Ian Maguire
Assistant Director Planning
& Economic Growth

RE: Responses to Deadline 7 Submission in respect of the Application by AQUIND Limited for an Order granting Development Consent for the AQUIND Interconnector Project (Deadline 7c).

In line with the Examining Authority's requests for Deadline 7c of the examination, please find responses on behalf of Portsmouth City Council in summary form set out below:

Figure 10: Affected area – Jct. A2030 / Fitzherbert Rd – Portsmouth (on exit from Sainsbury Car Park / Direction of travel of the abnormal load).

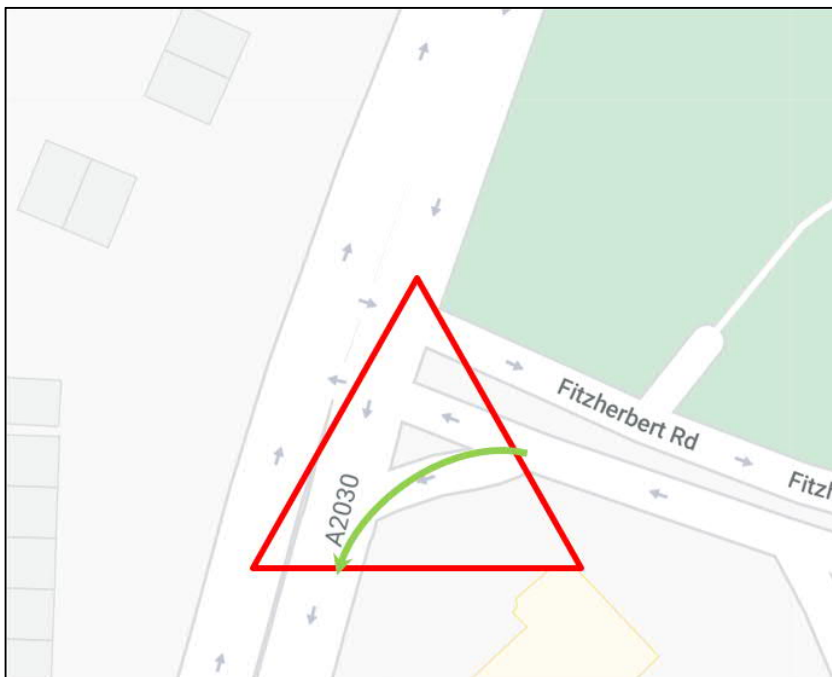
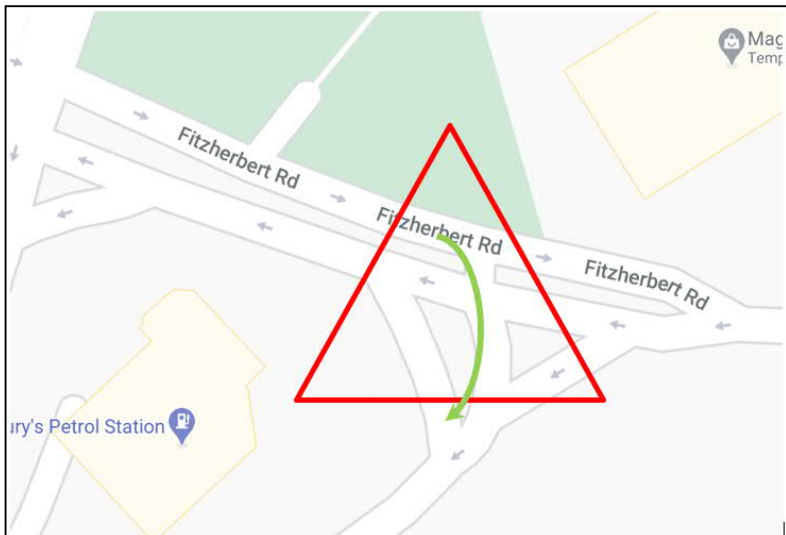
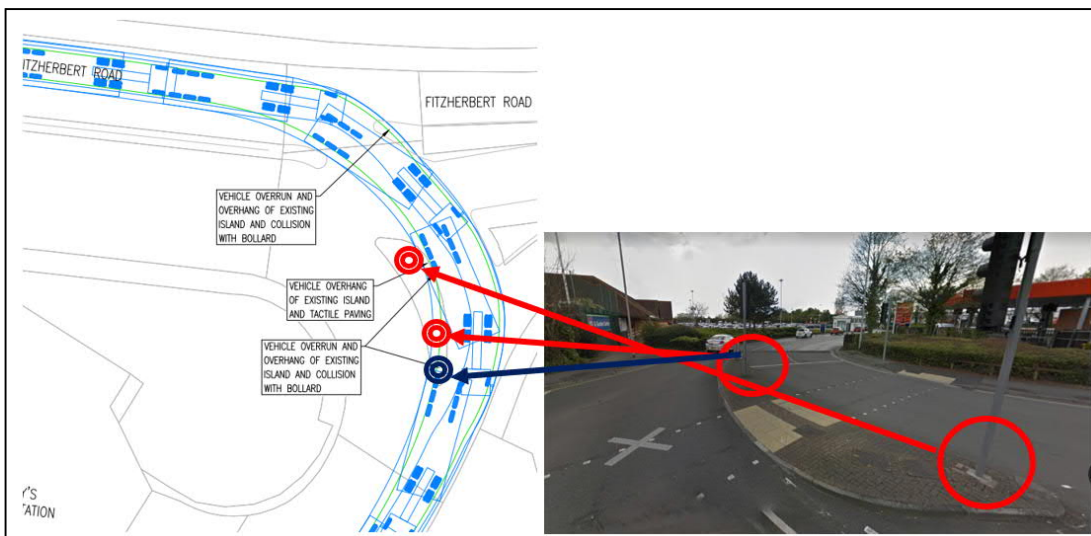
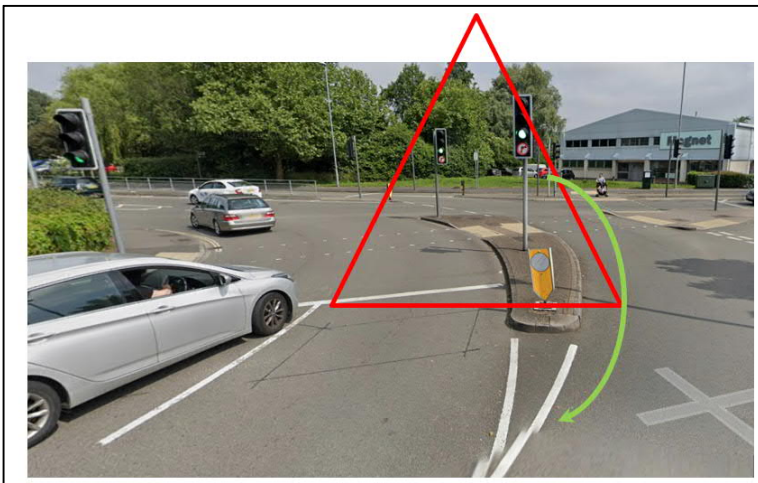
- 2.8 This updates REP6-070 Joint Bay Technical Note and addresses the PCC concerns raised that the then proposed location of the joint bay at Zetland Field would obstruct the planned access to the highway and not allow space for a vehicle to turn on site

**APPENDIX 1
CAR PARK PLAN**

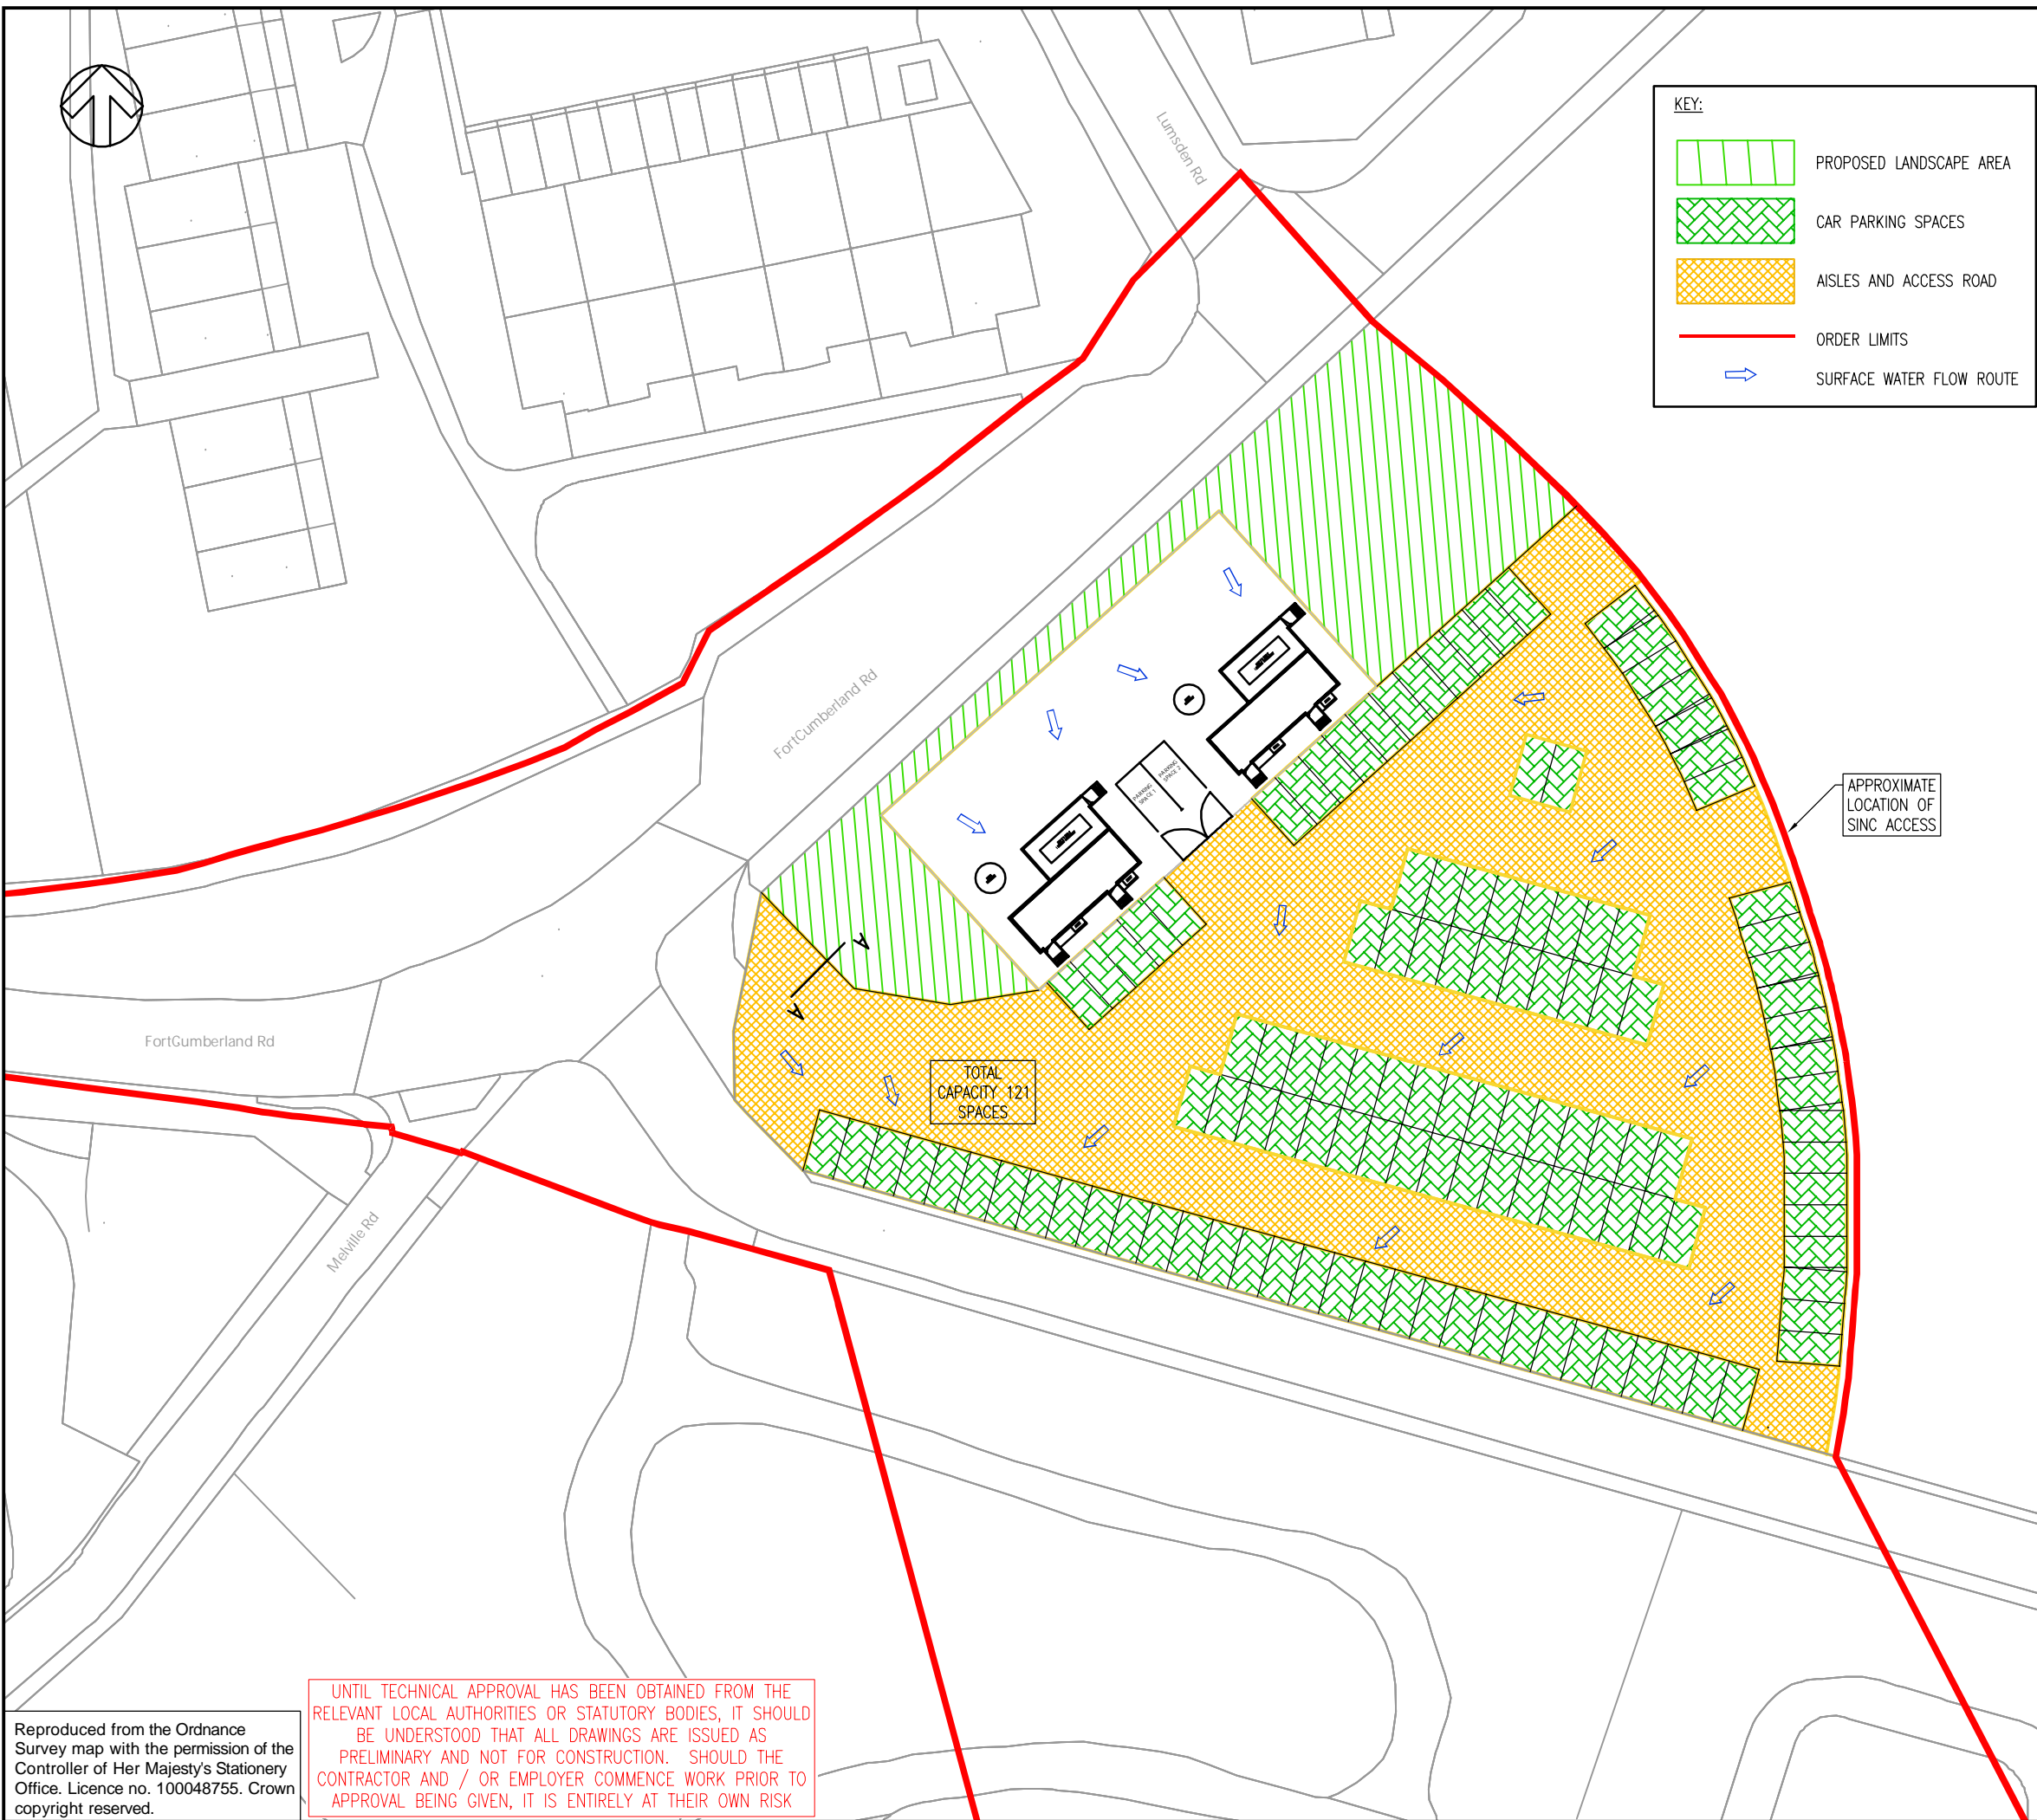
- 5.1 The two car park layouts within the below referenced drawing are in PCC's opinion misleading; drawing number AQ-UK-DCO-TR-LAY-006 indicates that, at present, the car park (which is not marked up) can accommodate 106 car parking spaces. Drawing number AQ-UK-DCO-TR-LAY-007 indicates that, despite a significant area of land being taken from the car park for the ORS building (and associated screening), the number of car parking spaces increases to 109 (due to the assumption that spaces are marked out).

- 5.2 PCC considers that this is quite clearly a nonsense; the simple act of marking up of bays does not increase the capacity of the car park. The assumption regarding the area required per car parking space should be the same to assess the loss of spaces with and without the ORS building/screening. No attempt has been made by the Applicant to consider the lost opportunity cost arising from the loss of this land. PCC note that should the Council have chosen to surface and mark the car park this is likely to have provided circa 150 spaces (circa 40 more than the applicants are suggesting in their proposed mitigation) and further consideration could have reasonably been given to future opportunities such as the introduction of parking charging in peak periods due to the location and accessibility to the seafront or to the installation of electric charging points for a significant number of the spaces on this site, as being rolled out elsewhere within the city, to meet the future demand for residential car charging as a preference to providing those on street. That would provide an opportunity to both meet an emerging demand and develop an income stream. As such the presentation of a net gain of car parking spaces and a subsequent positive residual implication of the works is totally misleading and inaccurate.
